**Planning Department
Arun District Council
Maltravers Street
Littlehampton
West Sussex
BN17 5LF**

Ref: 65/planning letter 01
ADC Ref: EG/47/13

**1 Spinney Walk, Barnham, PO22 0HR
Householder Application**

SITE PLAN 1:500

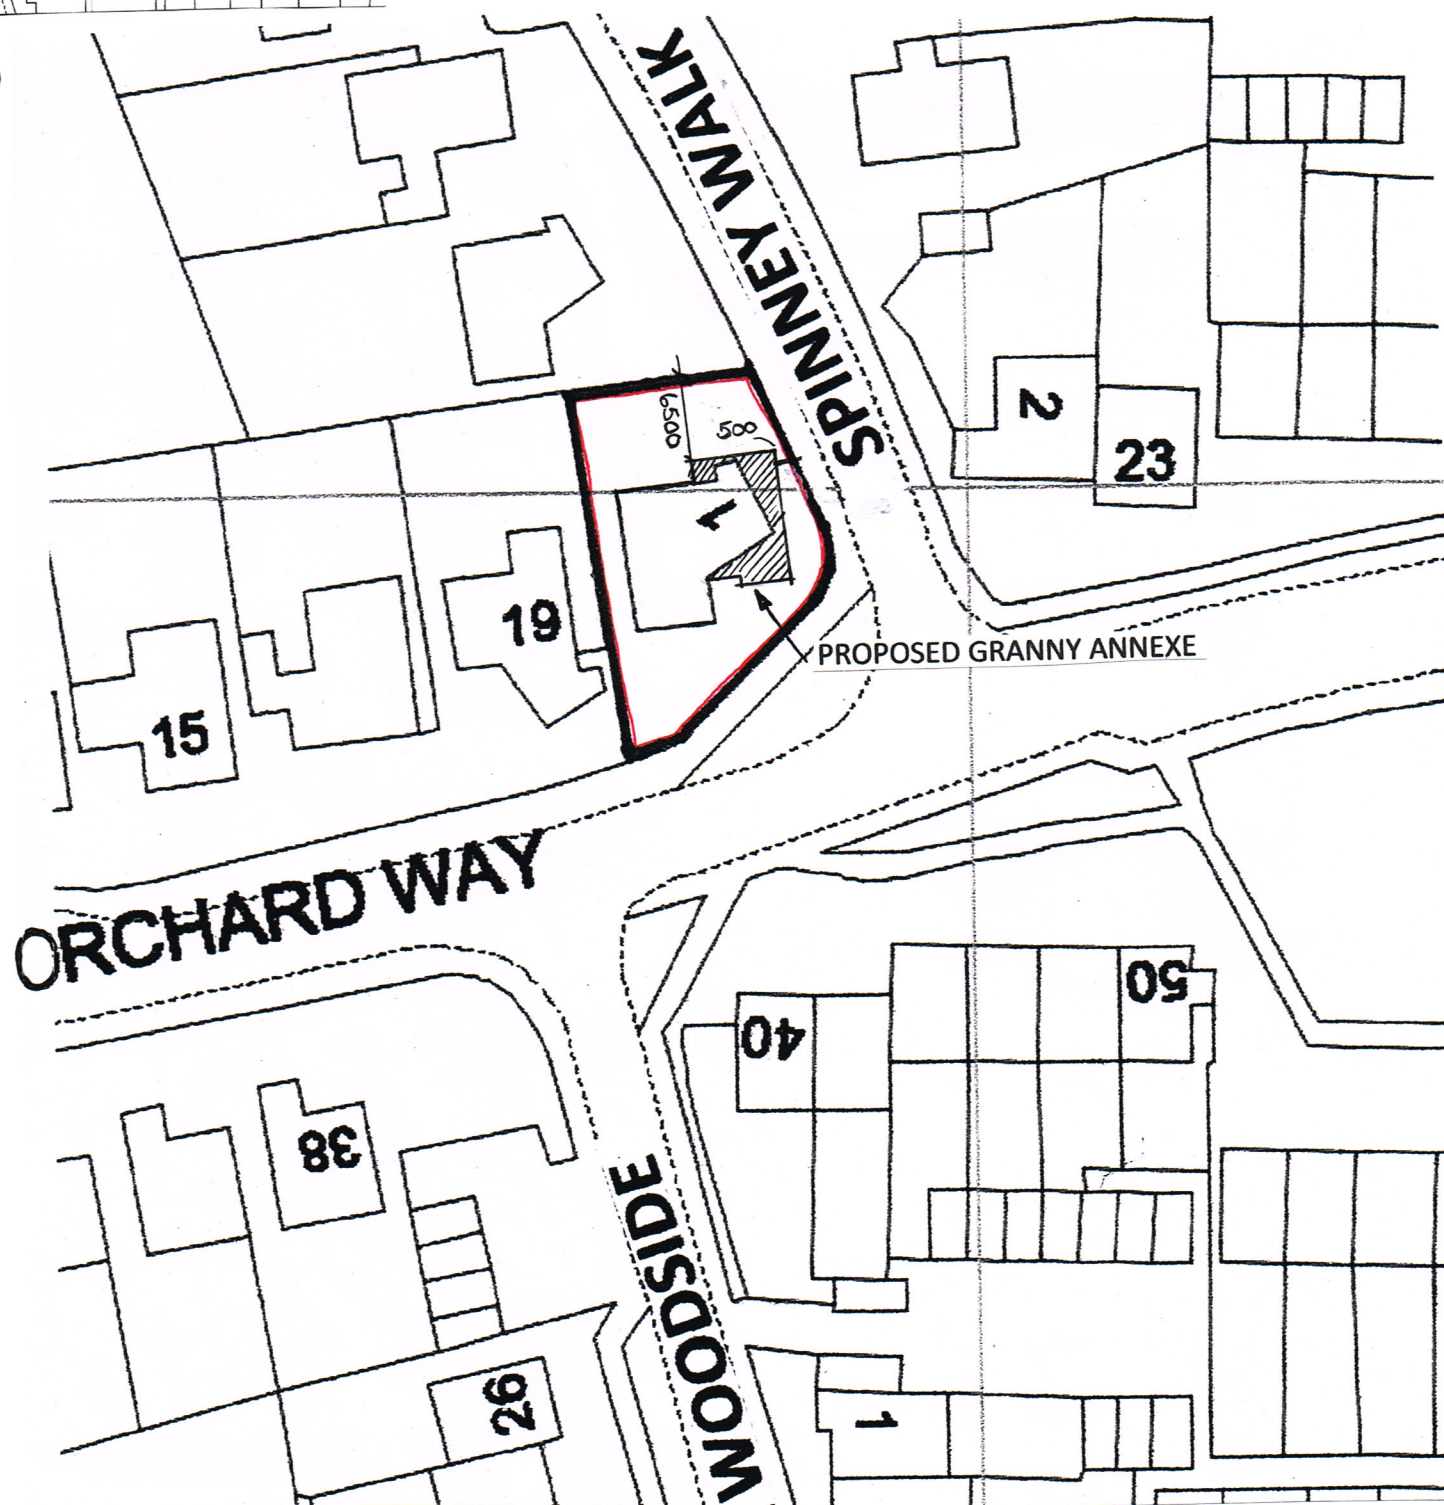
Block Plan – dimensions have been added and a revised plan attached.
